Item No. **Report of the Head of Planning, Sport and Green Spaces**

Address 76 ELLIOTT AVENUE RUISLIP

Development: Two storey side extension and single storey rear extension involving demolition of existing attached garage

LBH Ref Nos: **69425/APP/2013/3711**

Title PROPOSED SECTION A A

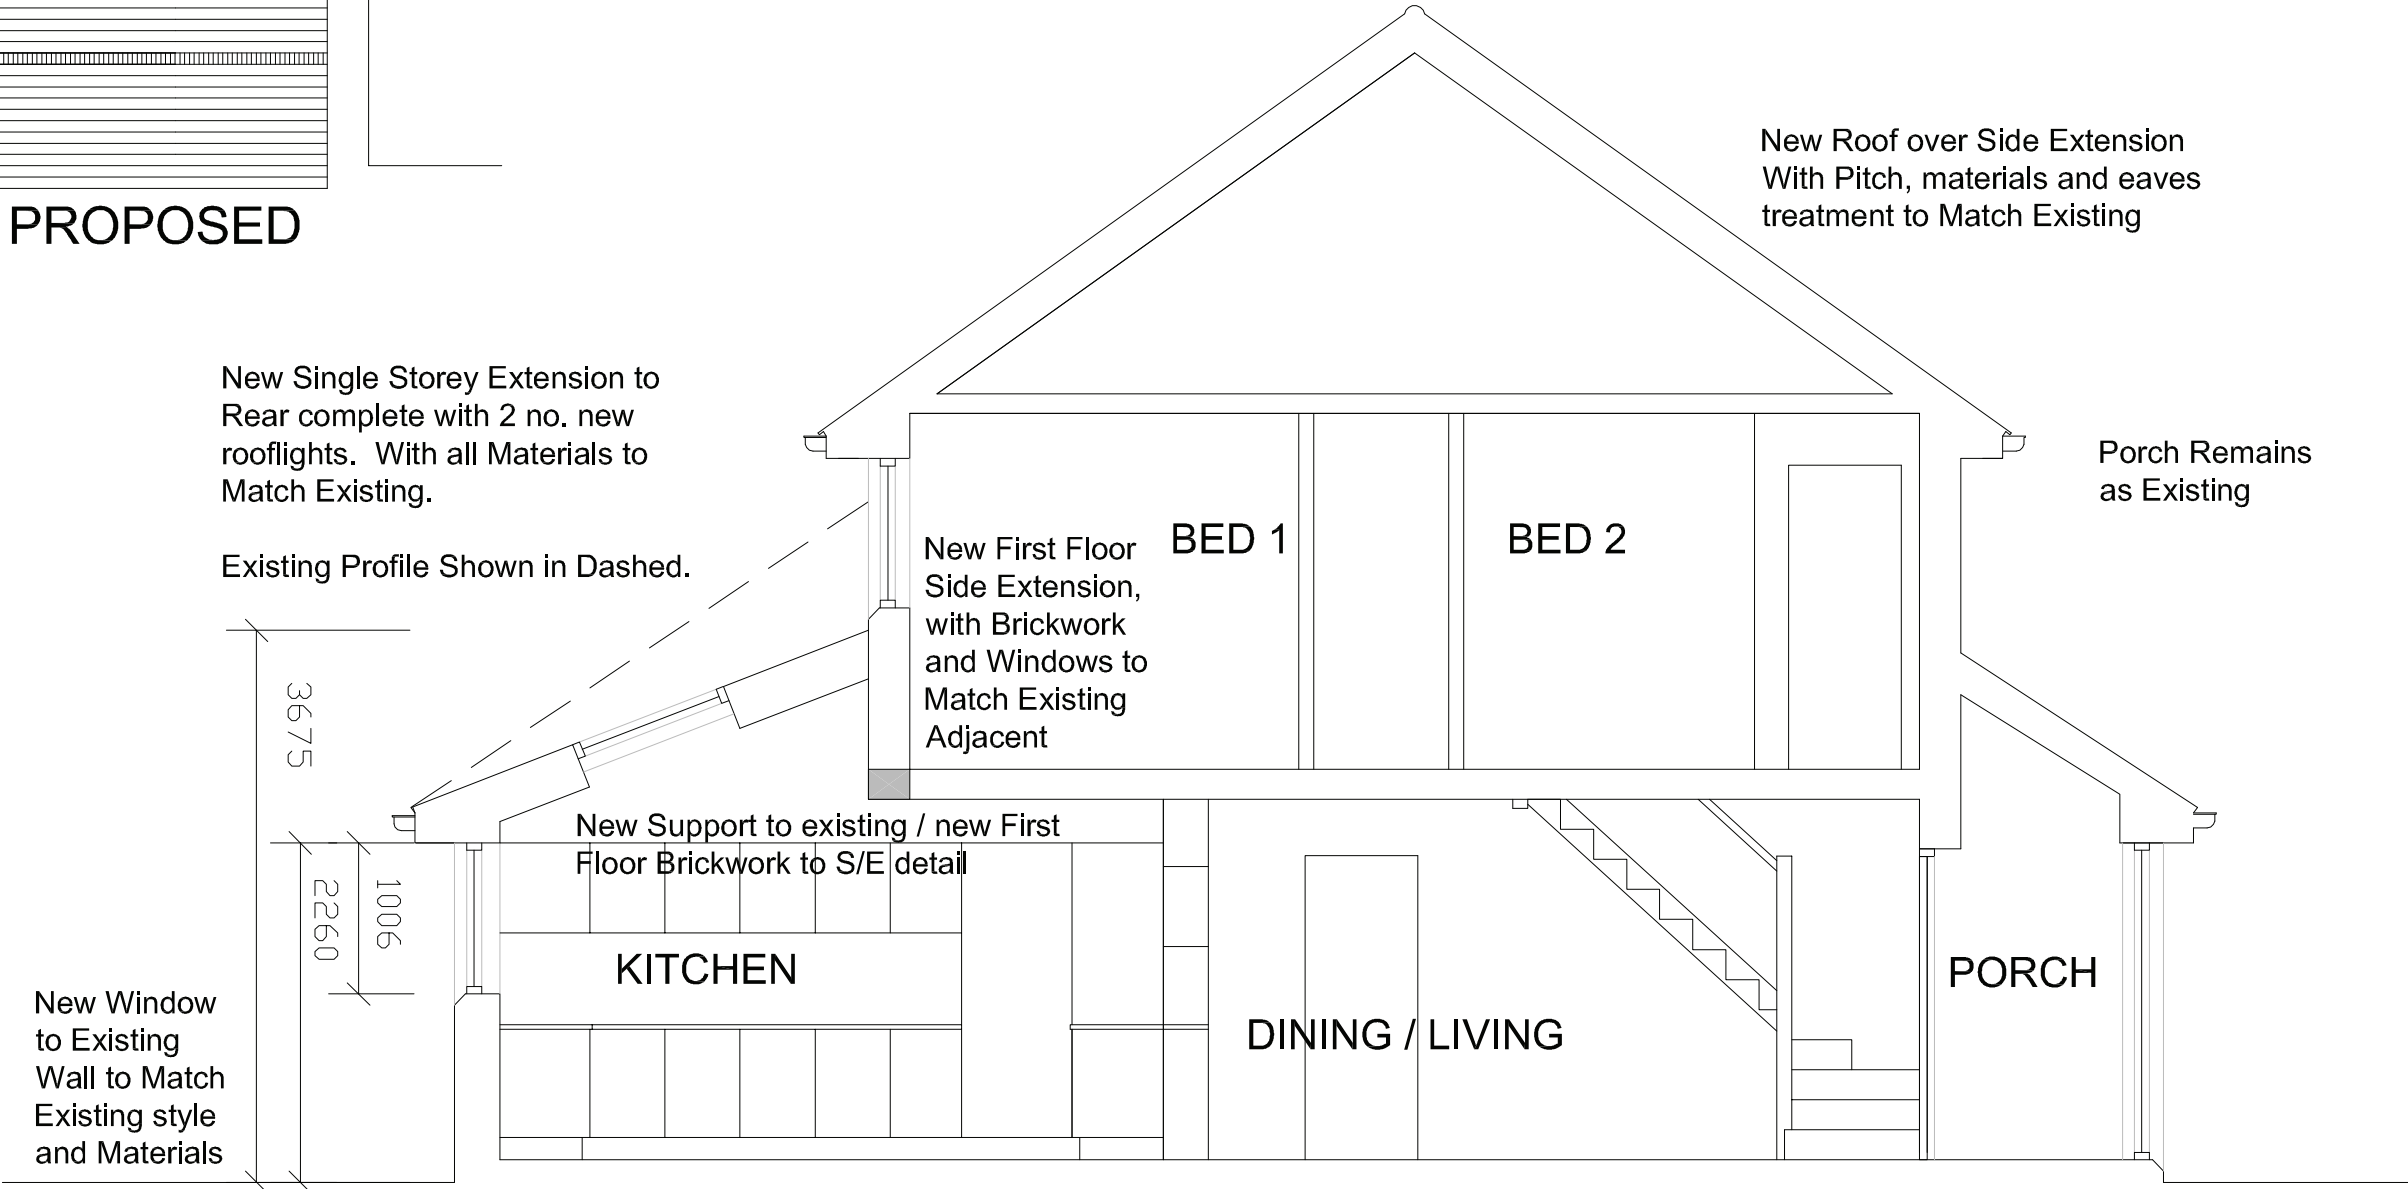
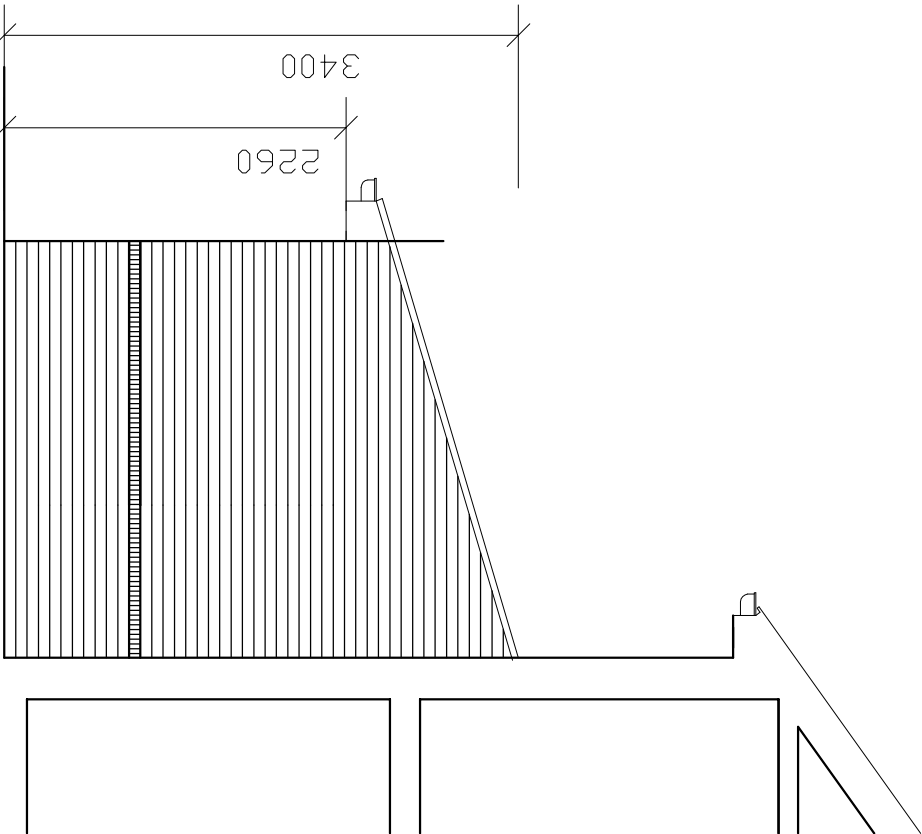
Turning to the single storey rear extension, it would project 2.75m from the rear wall and extend to the width of the original dwellinghouse on a plot more than 5m. This is considered acceptable in respect of guidance contained in 3.2 of the HDAS-EXT supplementary planning document. Its height would match the maximum height of 3.4m in line with guidance contained in paragraph 3.7. Therefore, the rear extension is considered to have an acceptable impact on the appearance of the dwelling.

In terms of the impact on the neighbouring dwelling, the proposed rear extension would be compliant with the HDAS Residential Extension guidance in terms of its height and depth. Owing to its orientation with No. 78 Elliot Avenue and the height and depth of the rear extension, which would abut the boundary of no. 74 Elliot Avenue, it is considered that the proposed development would have an acceptable impact on the residential amenity of the neighbouring occupiers, in accordance with Policies BE20 & BE21 of the Hillingdon Local Plan: UDP Saved Policies (2012).

Title PROPOSED ELEVATIONS 1 OF 2		DWG No. 53 L(--) 300	Status. PLANNING
Revision.	P4	Scale. 1:50	Paper. A3

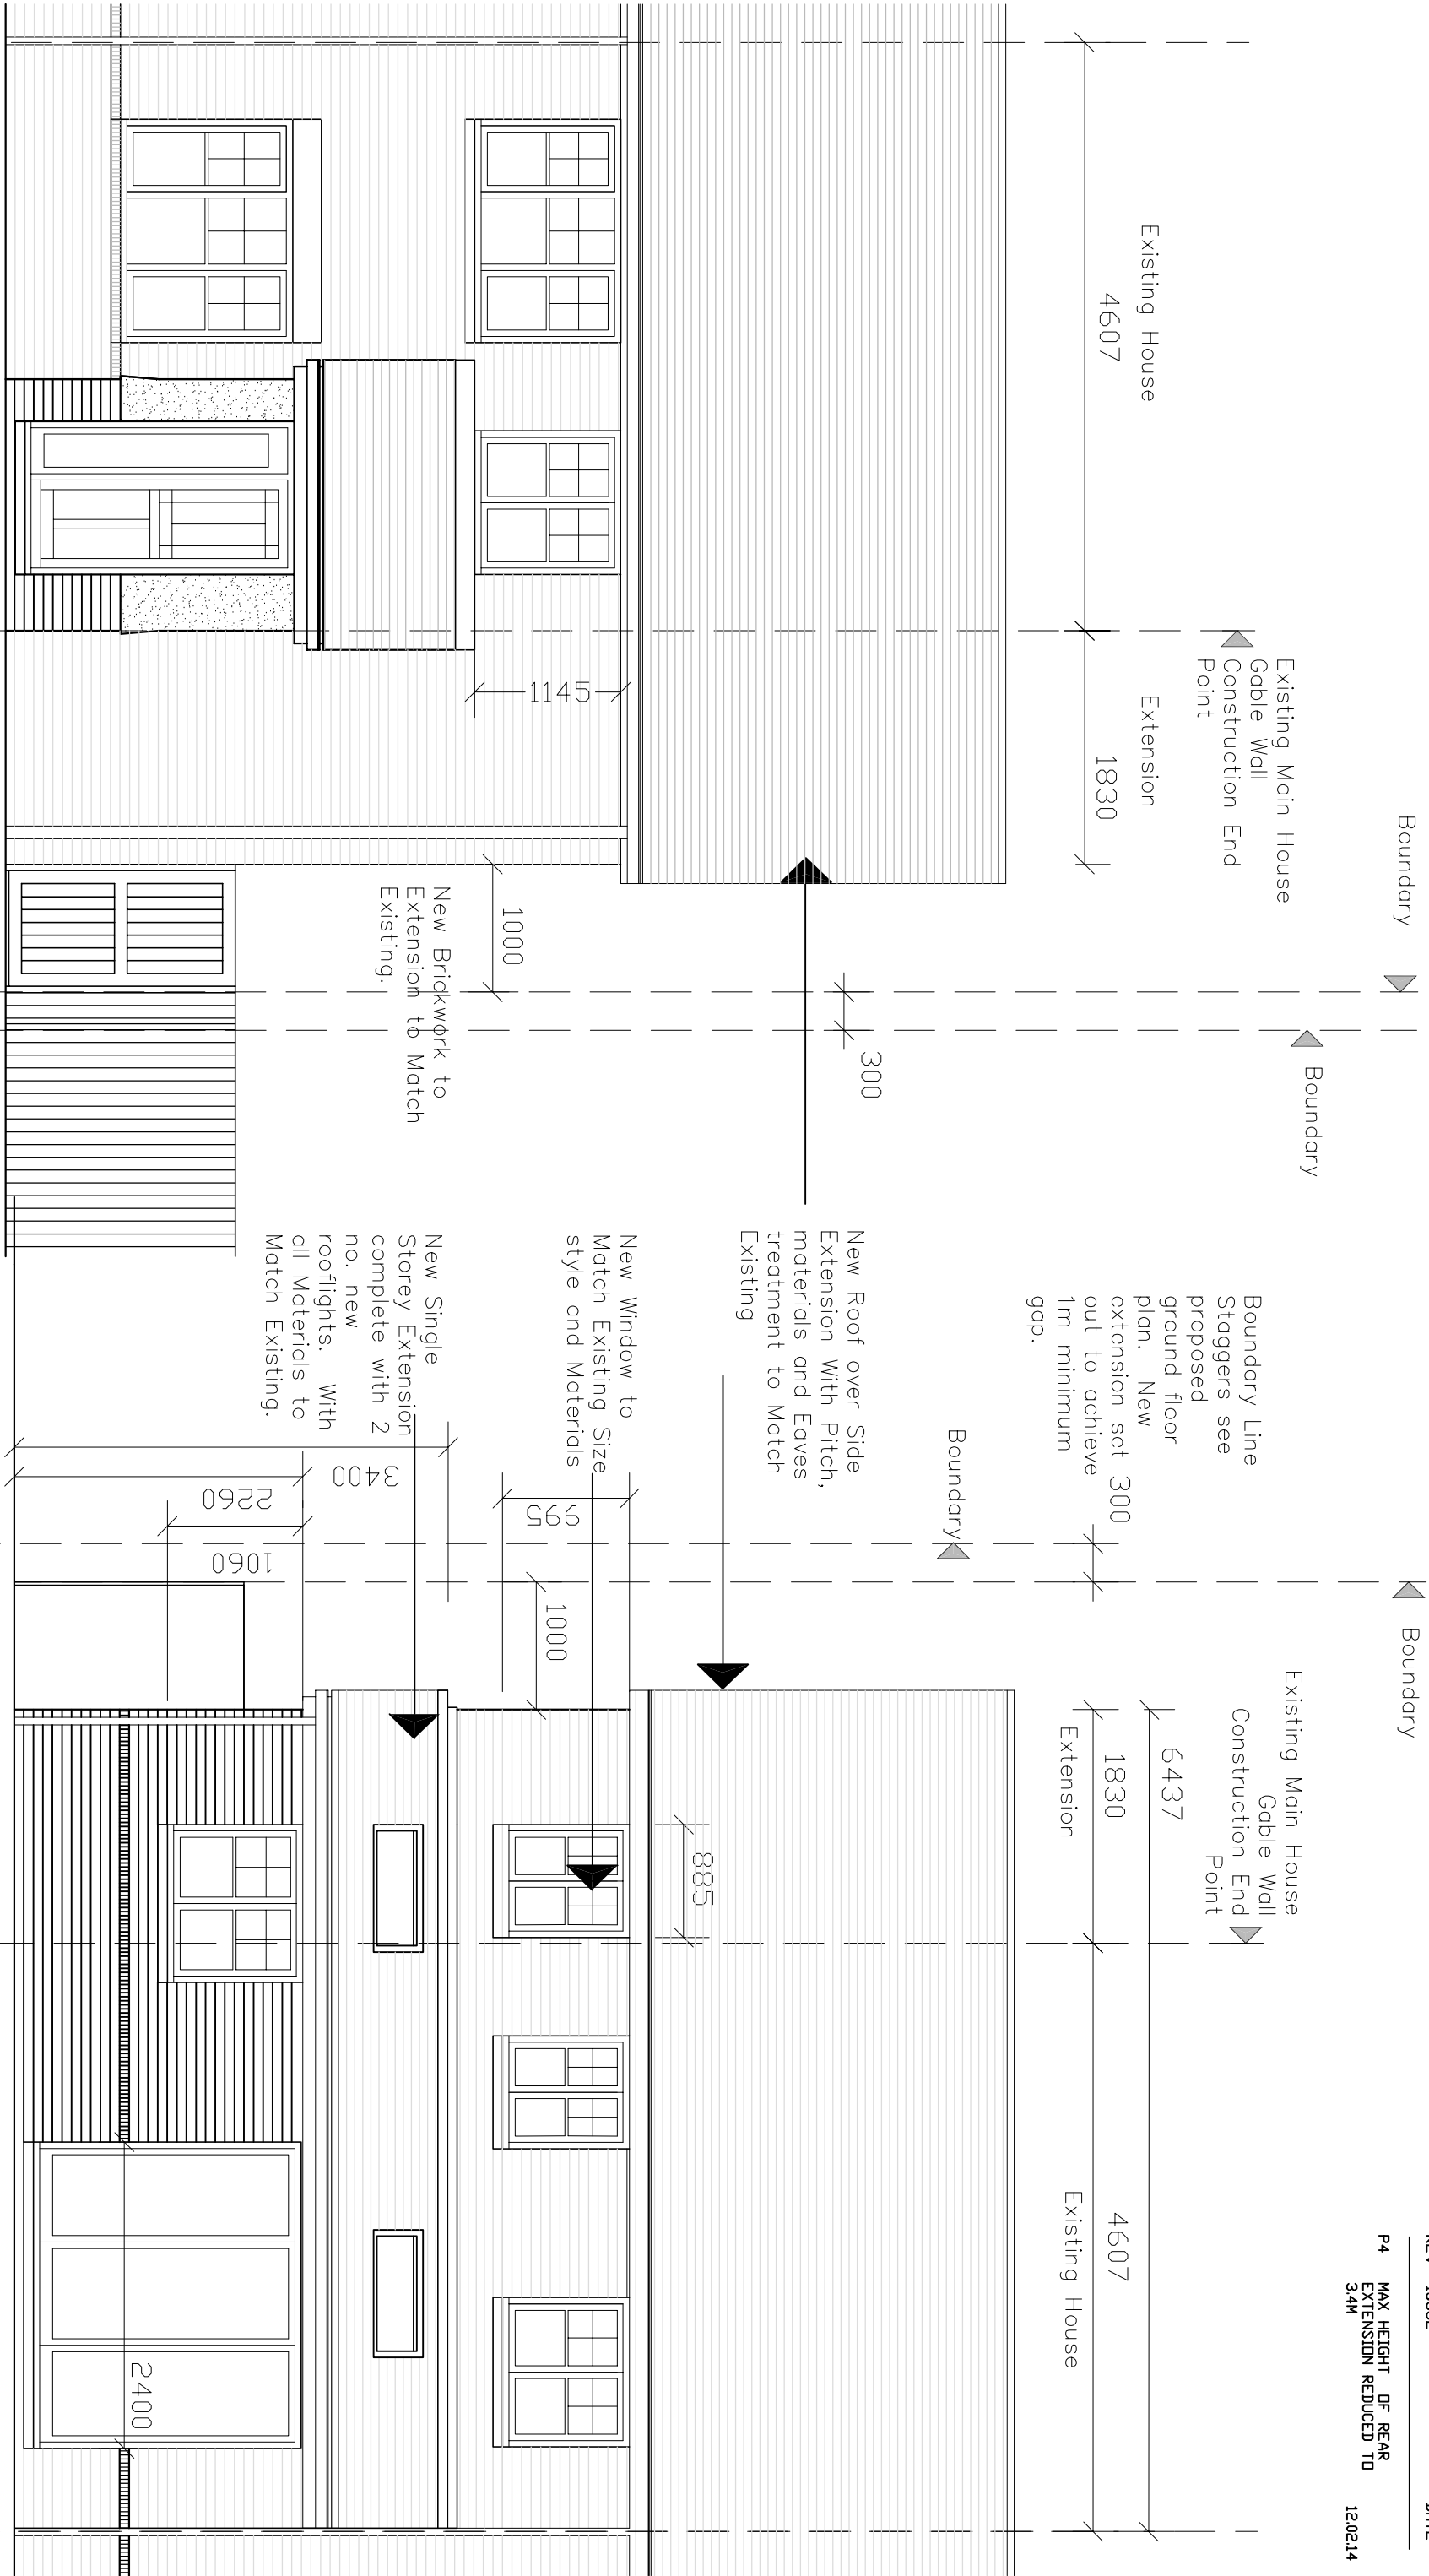
From a design standpoint, additional windows in the principle elevation facing the highway would have been preferred giving a more symmetrical appearance rather than a blank wall but this is not enough to warrant refusal on these design grounds only.
